Re: Block 2 & 2A PA – Council Letter 17/11/09

Noted discrepancies March 21, 9am:

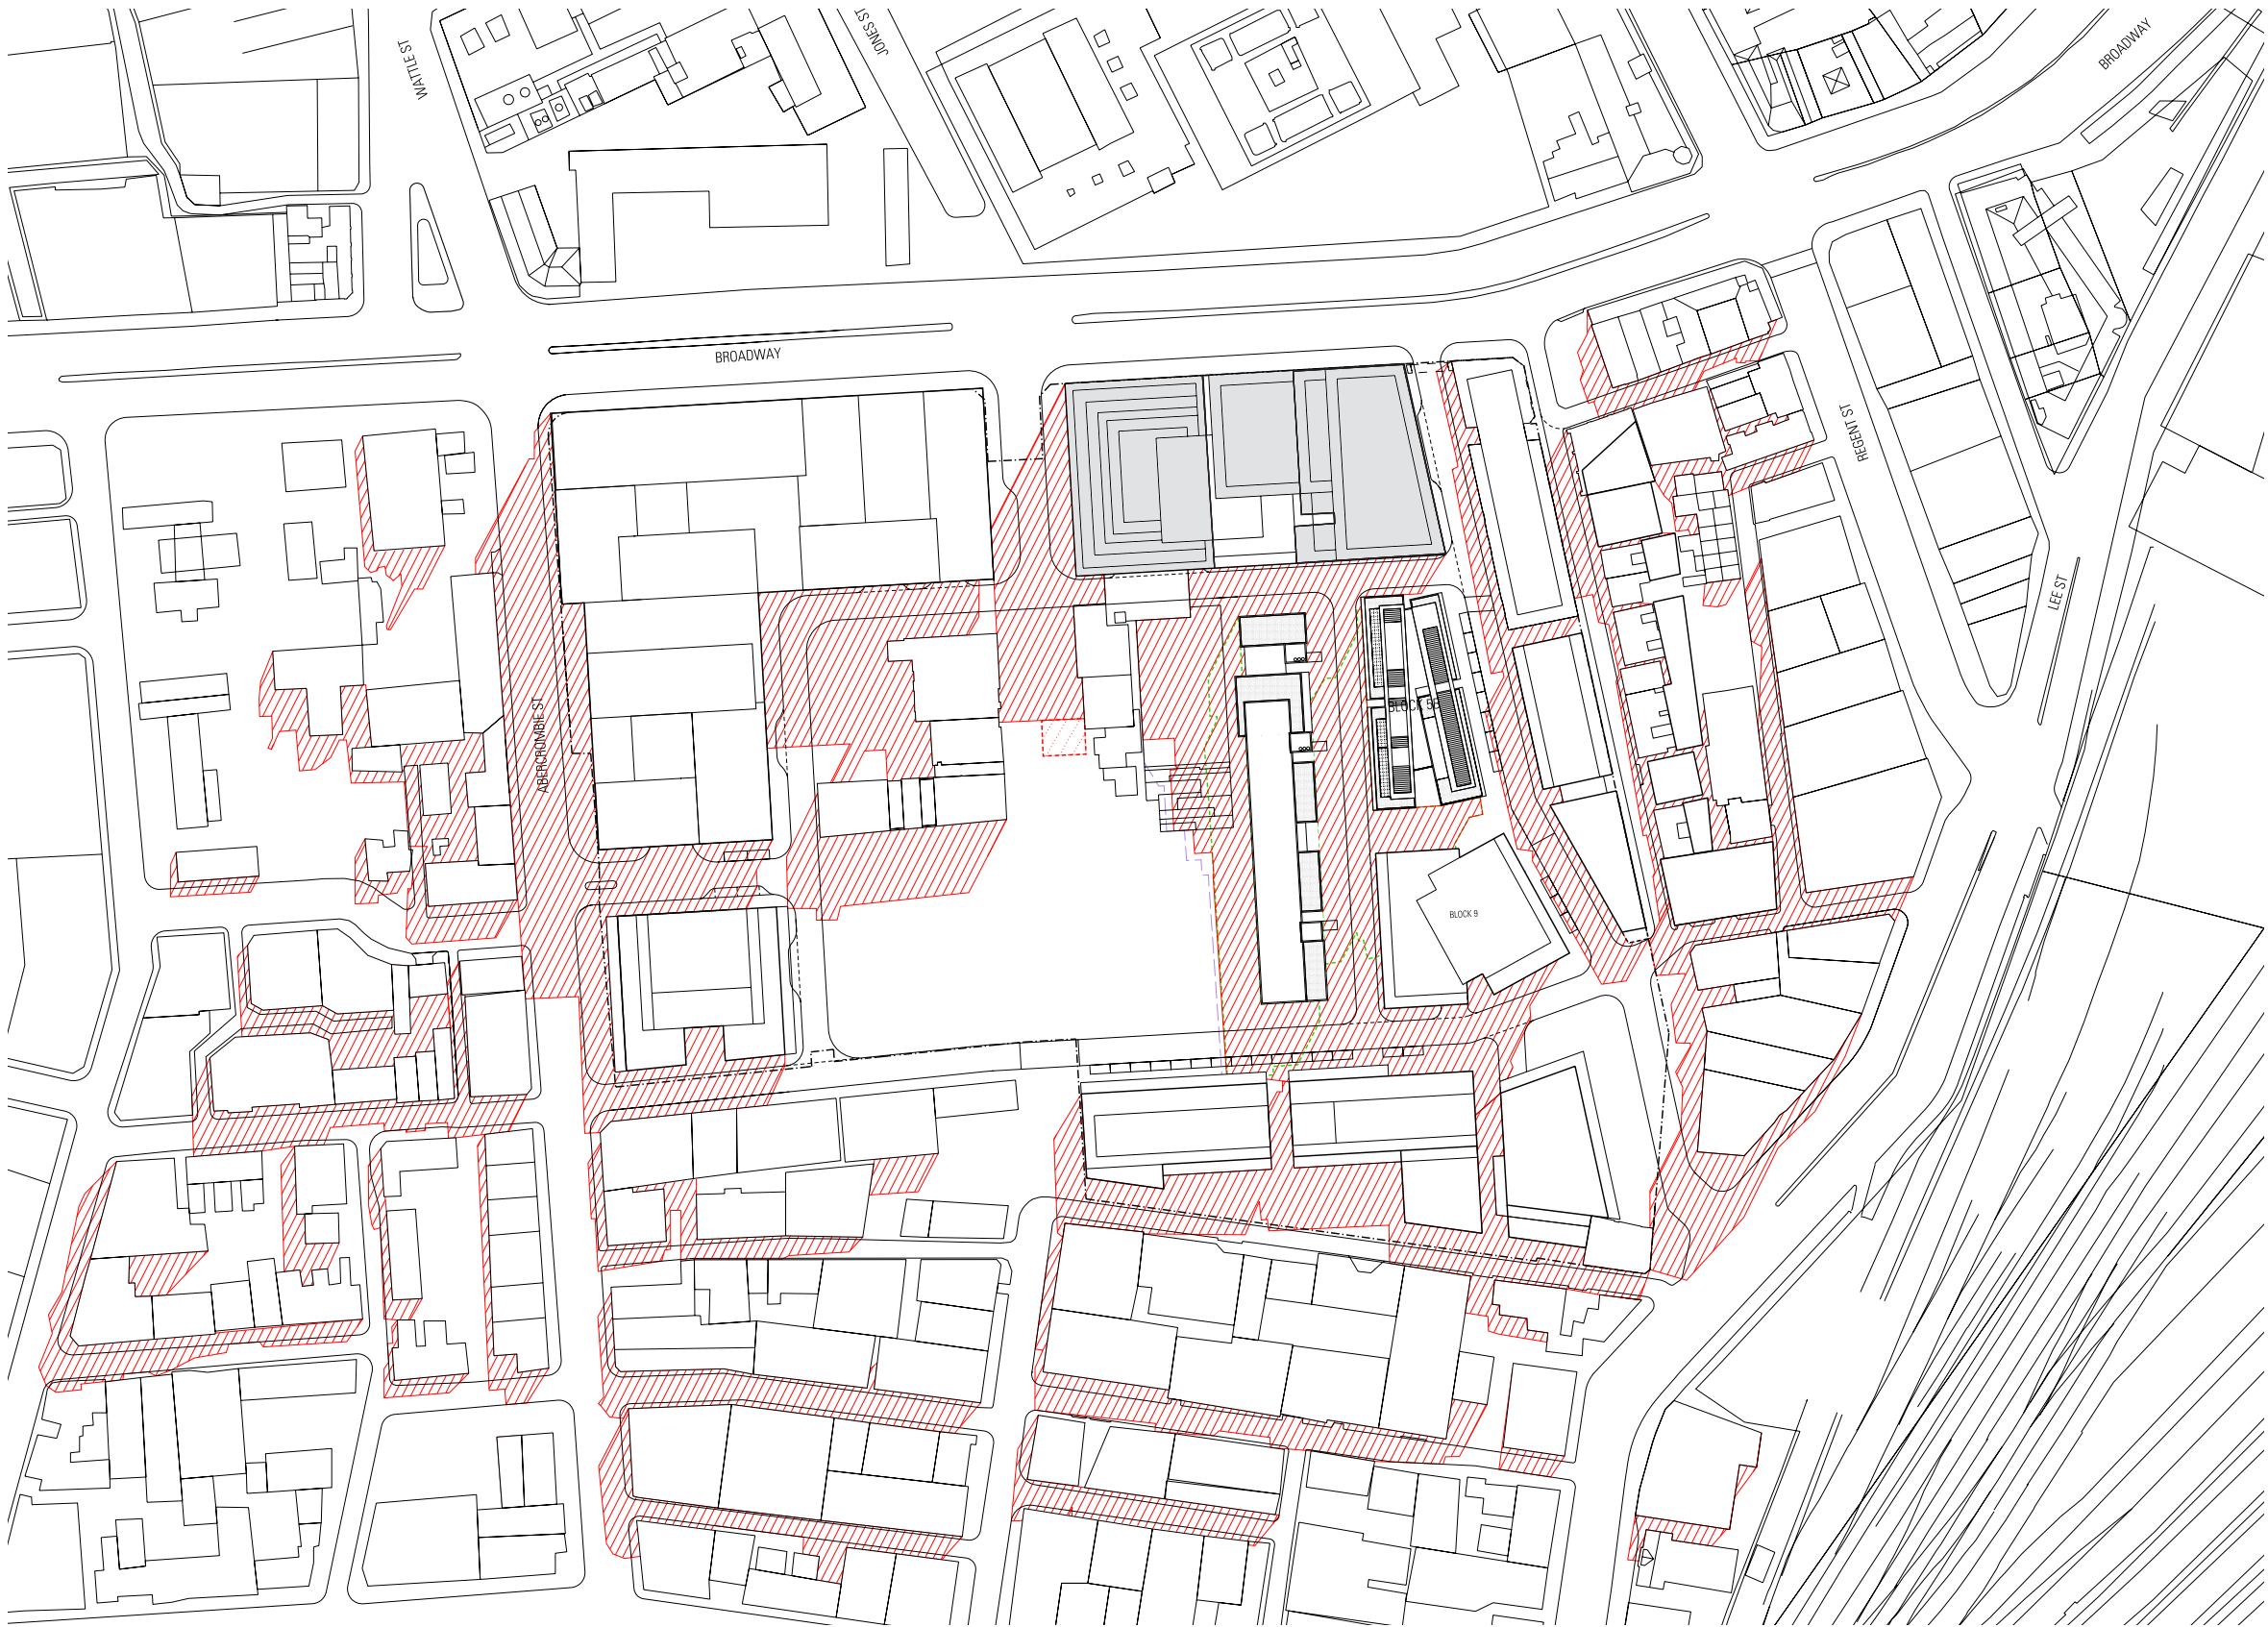
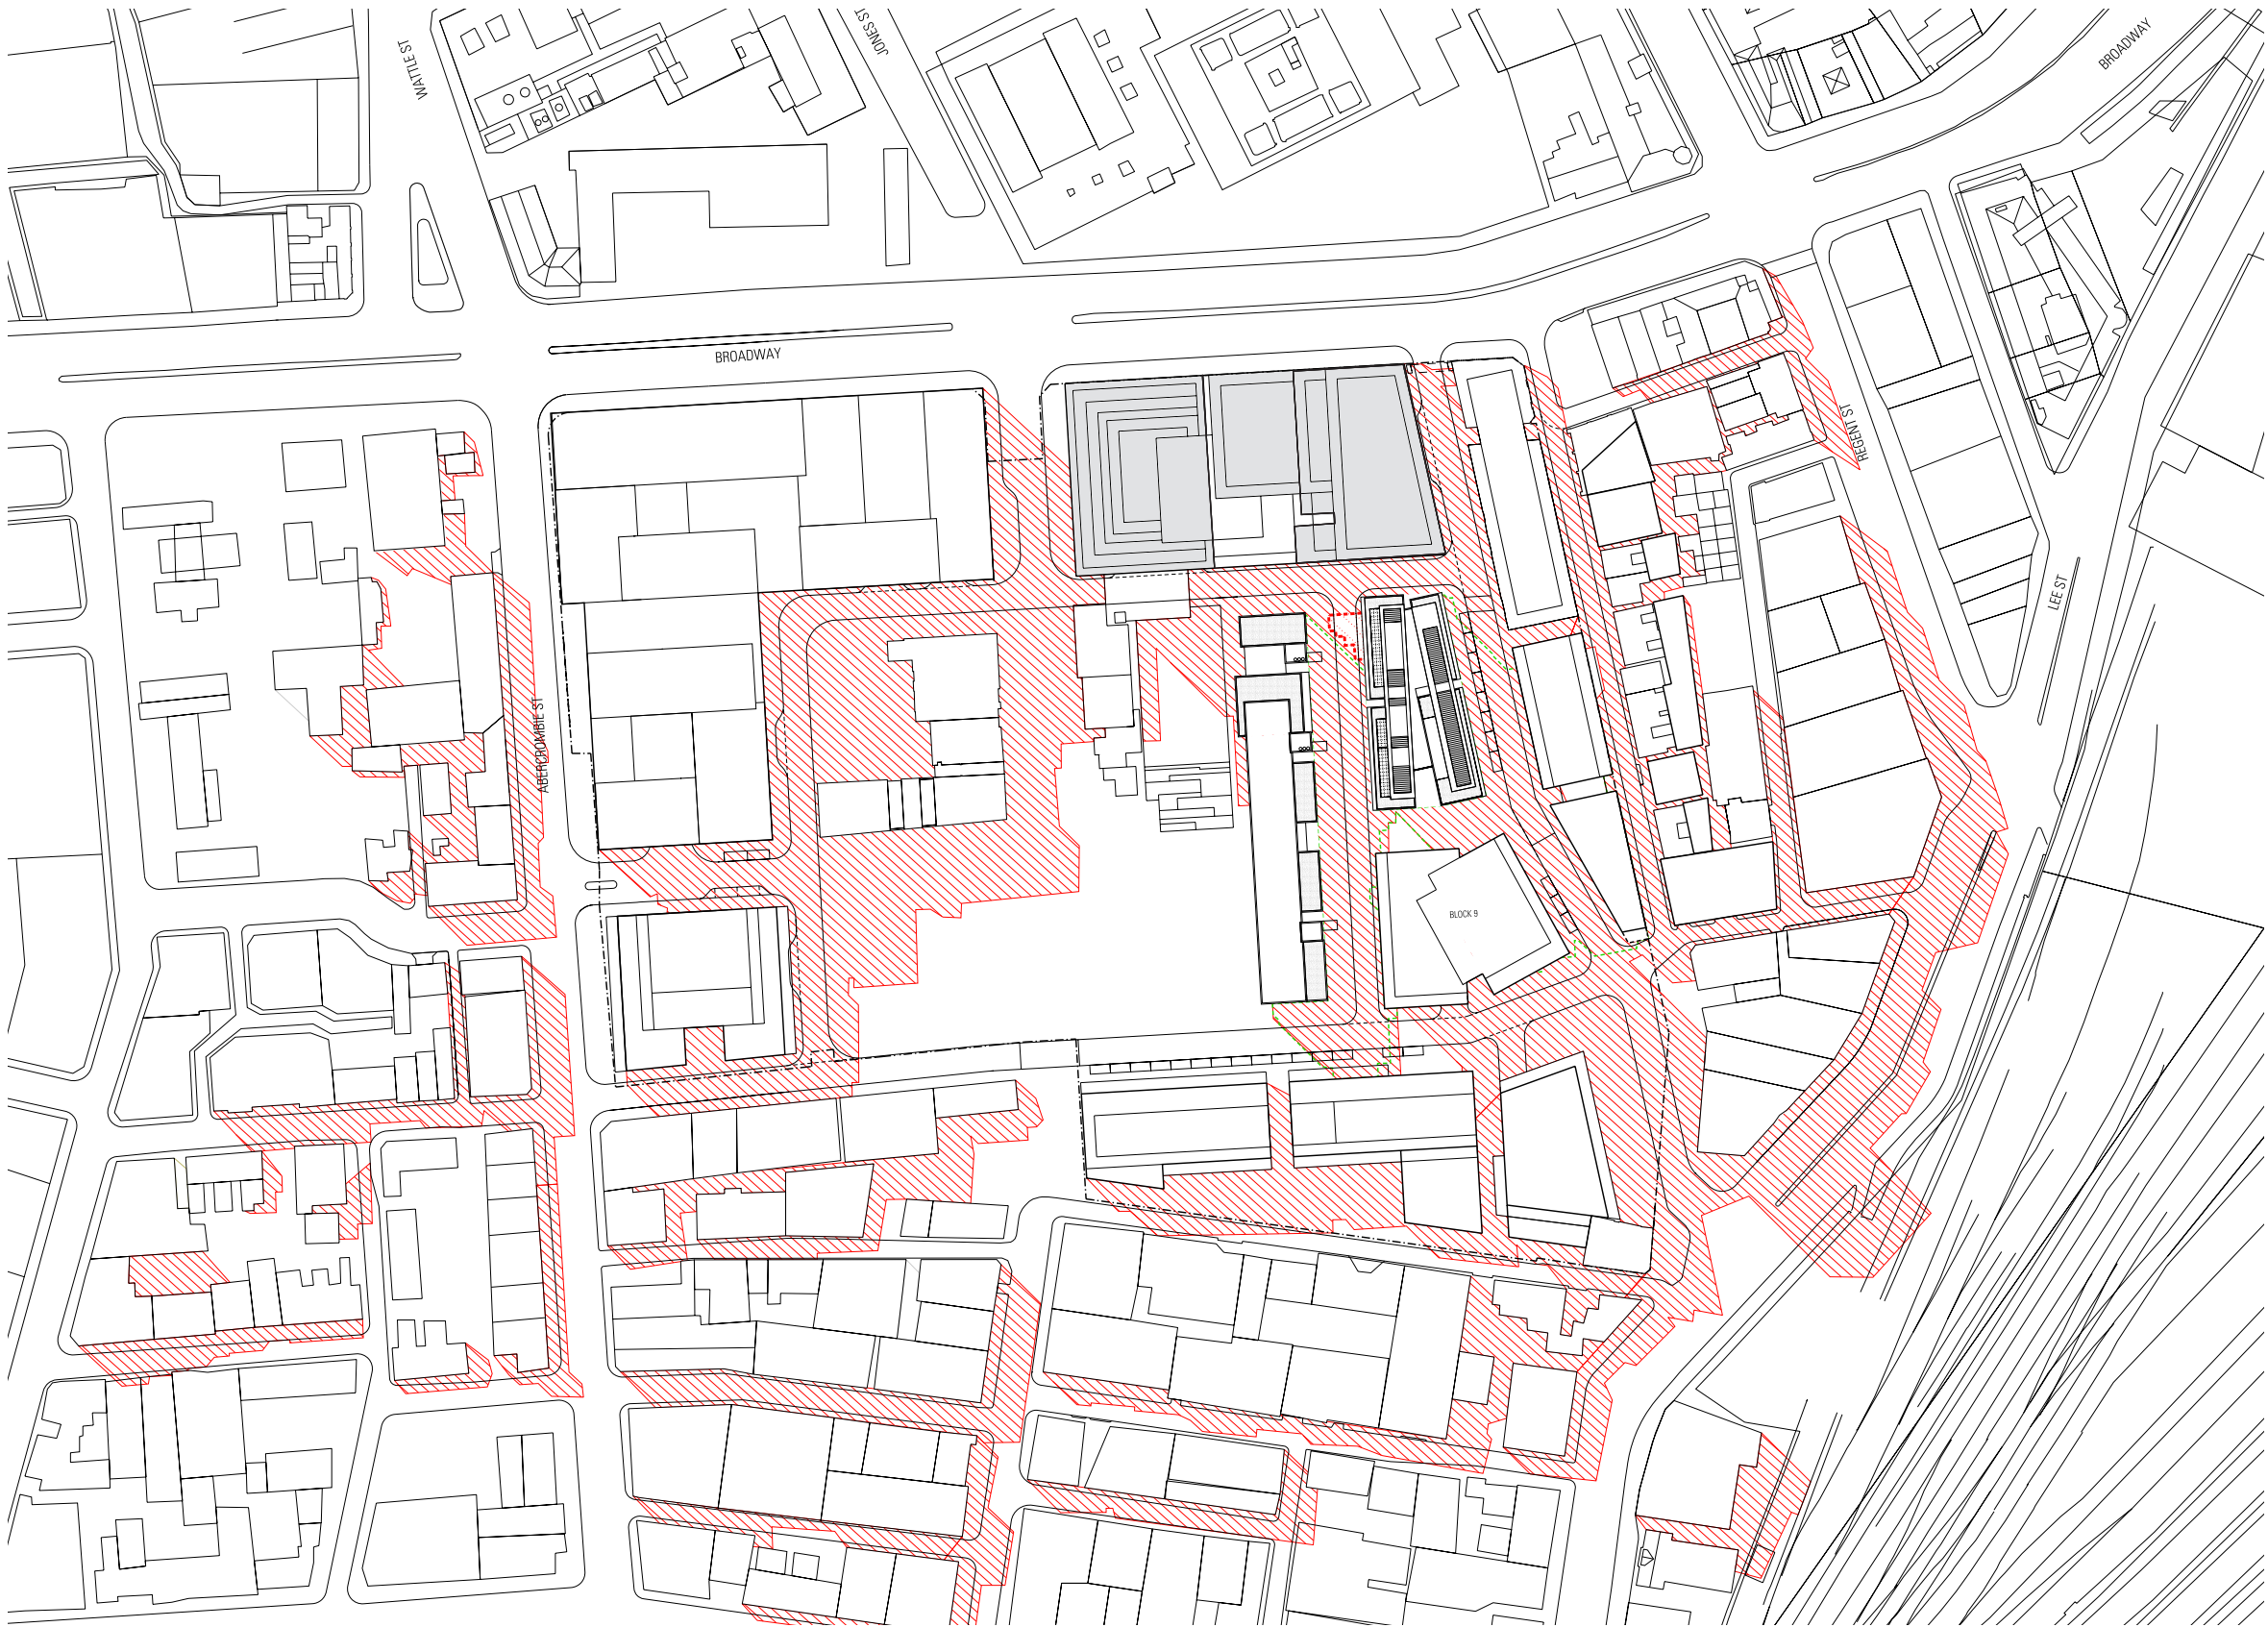
Condition	Approval Authy	Timing	By and Comments
	CoS Letter			
URBAN DESIGN				
Pt1	Height Scale and Massing	Note		This is responded to in the body of the PPR. Frasers and AJN do not accept COS comments.
Pt2	Street Activation	SCC		This is responded to in the body of the PPR. Frasers and AJN do not accept COS comments.
Pt3	Podium Finishes	SCC		This is responded to in the body of the PPR. Frasers and AJN do not accept COS comments.
Pt4	Public Art	SCC	Public Art submission	Frasers have submitted and the City of Sydney has endorsed the Public Art Strategy. The public art proposed for Block 2 will be agreed in principle with the City of Sydney prior to the issue of the CC. Subsequent detailing, procurement and installation will be undertaken in conjunction with the Council who shall provide approval prior to the Occupation Certificate being issued.
Pt5	Portal Finishes	SCC		This is responded to in the body of the PPR. Frasers and AJN do not accept COS comments.
